From: [Patrick Yamashita](#)
To: [Below, Matthew](#)
Subject: Mercer Island Transit Integration Project Completeness Review Status
Date: Wednesday, October 28, 2020 1:36:00 PM

COMPLETENESS REVIEW

The Sound Transit permit applications for the Mercer Island Transit Integration Project (the "Project") have been reviewed for completeness.

LANDSCAPE NOTES:

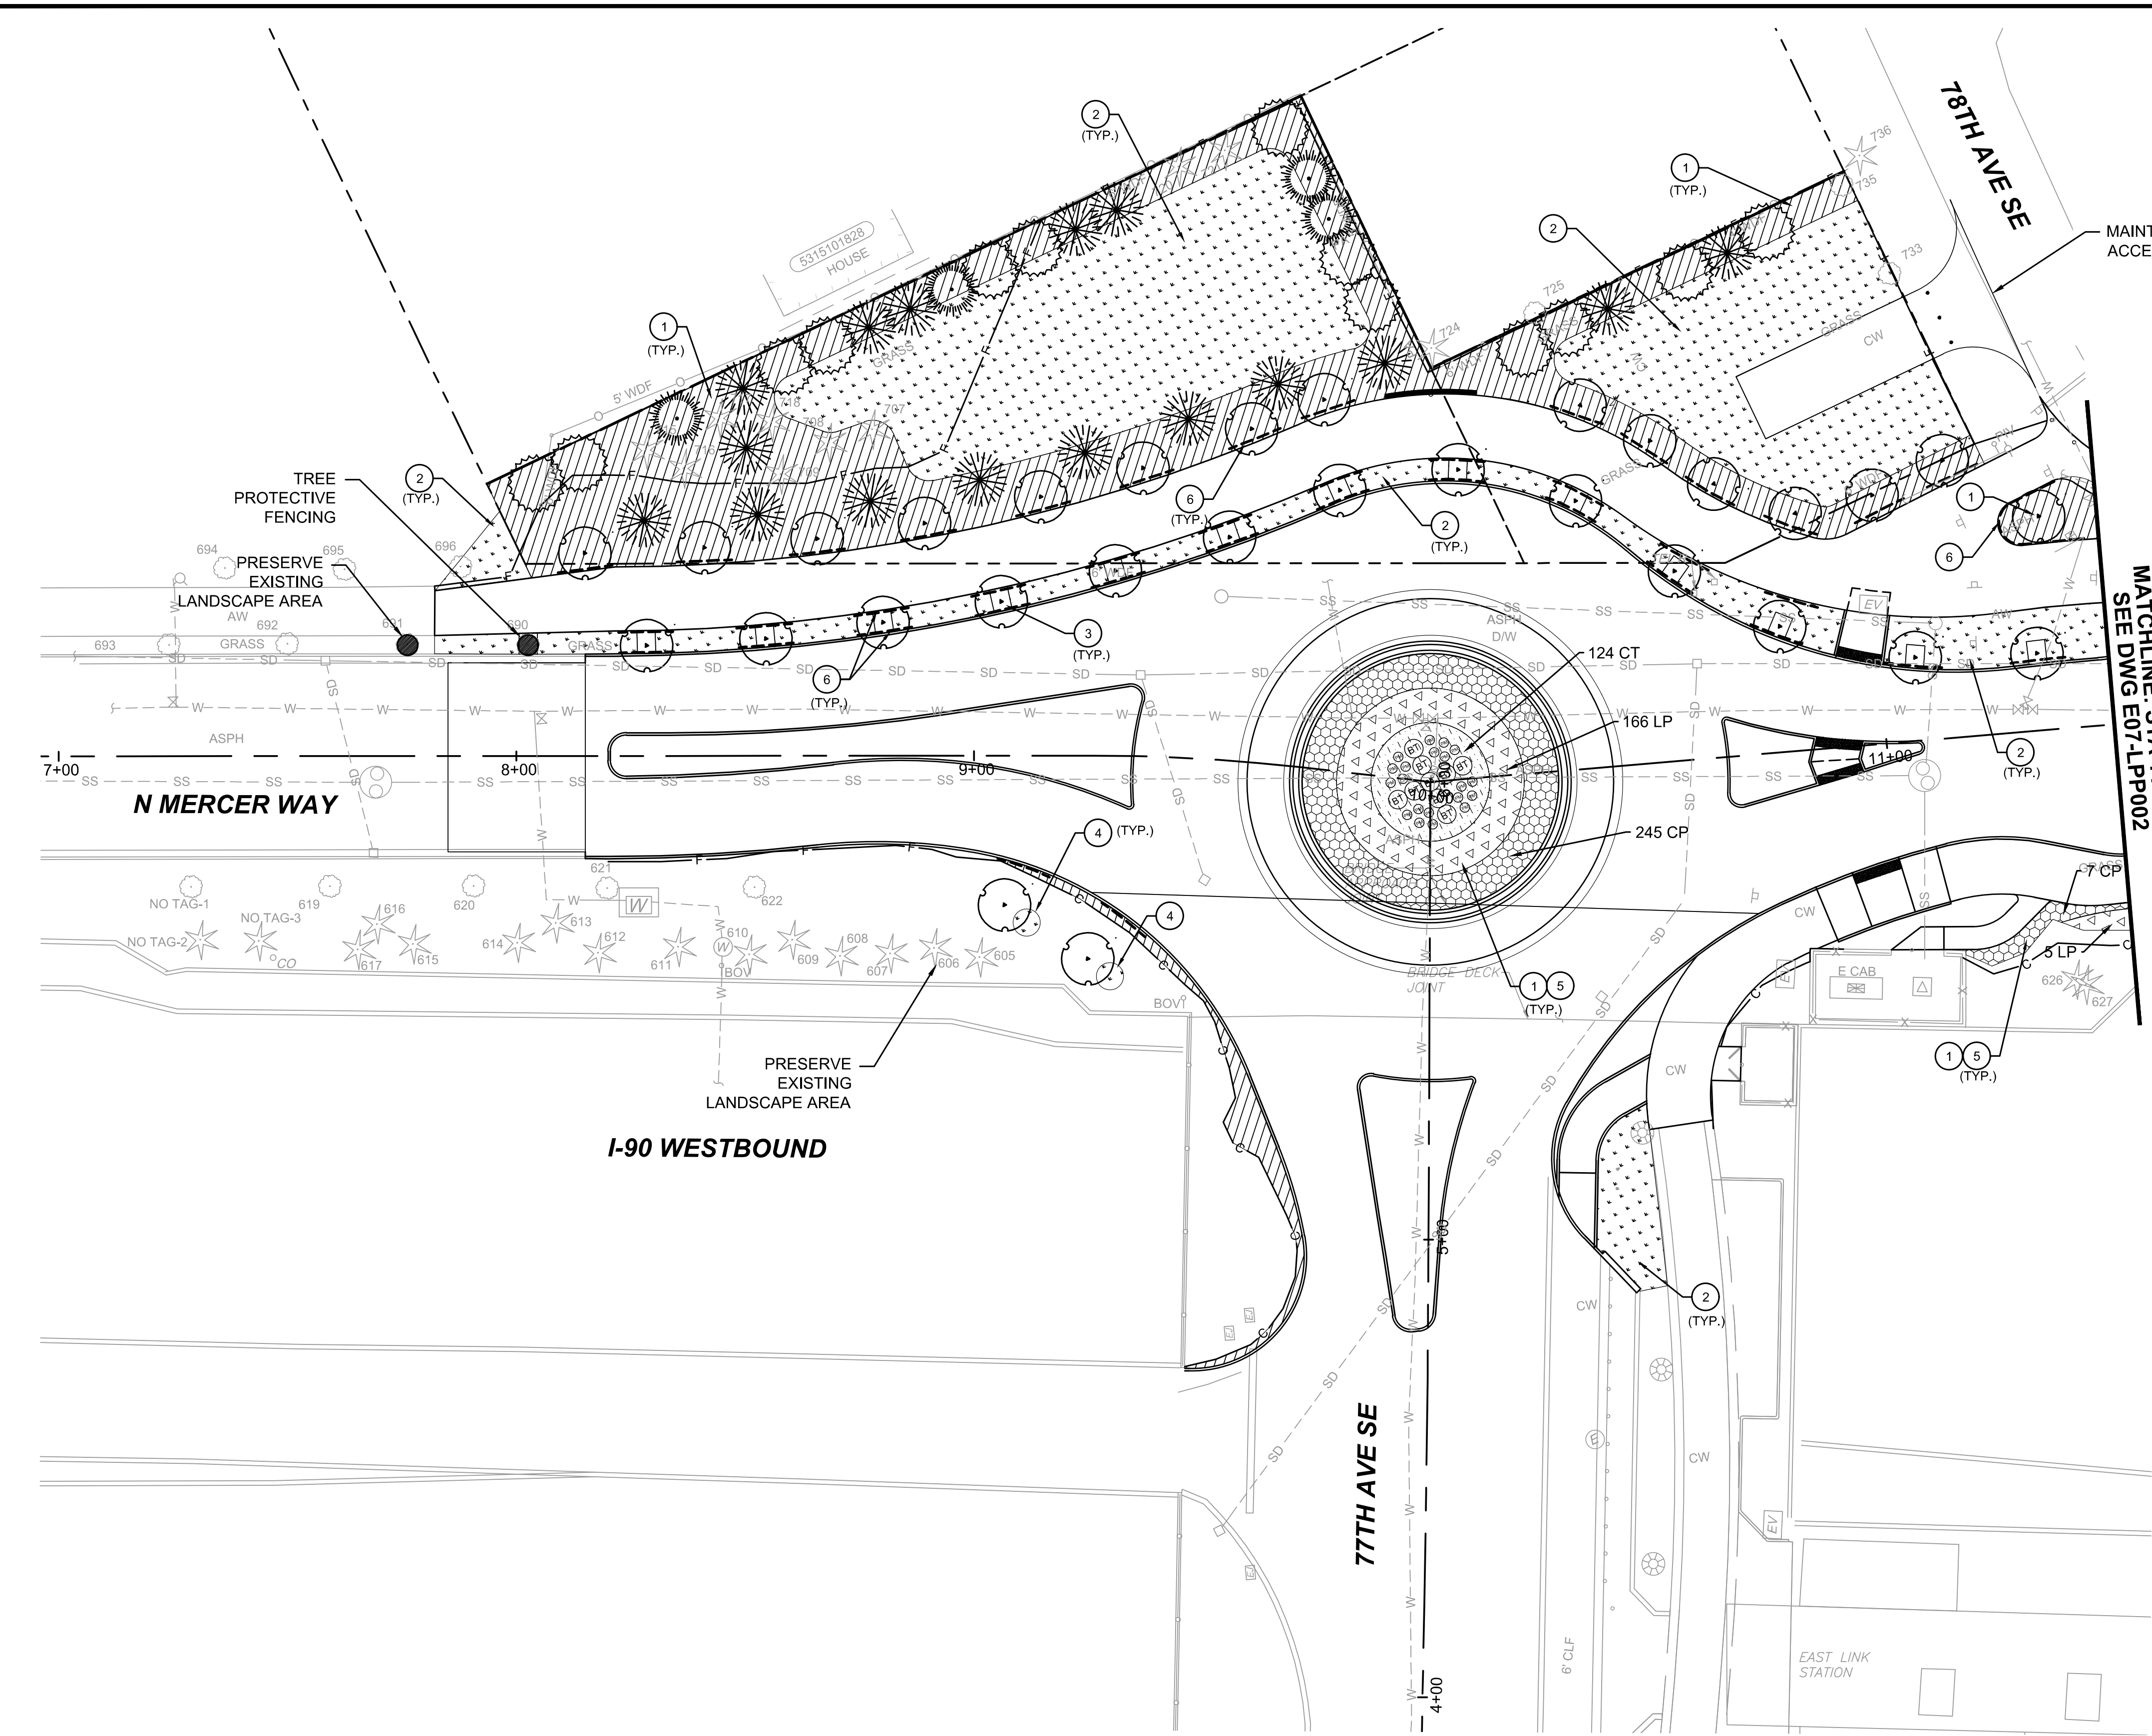
ROW use permit: CPD17 & CPD18 indicated not to plant large trees in roundabout near/over underground utilities and to show underground utilities on the landscape plans to help identify whether there may be conflicts between utilities and landscape improvements. ST responded by adjusting from multiple trees to one tree stating that it would be away from utilities and that landscaping was previously coordinated with CMI fire department. Coordination must also be with Public Works engineering who reviews water, sewer, and stormwater system impacts. Please note that the proposed tree is located directly on top of the City's sewer main and water main, hence the reason for the request to show utilities (water, sewer, storm). This is not an acceptable location for the tree. Show utilities and adjust tree location. Please contact the Senior Development Review Engineer (ruji.ding@mercergov.org) and we can work together on determining a

better tree location.
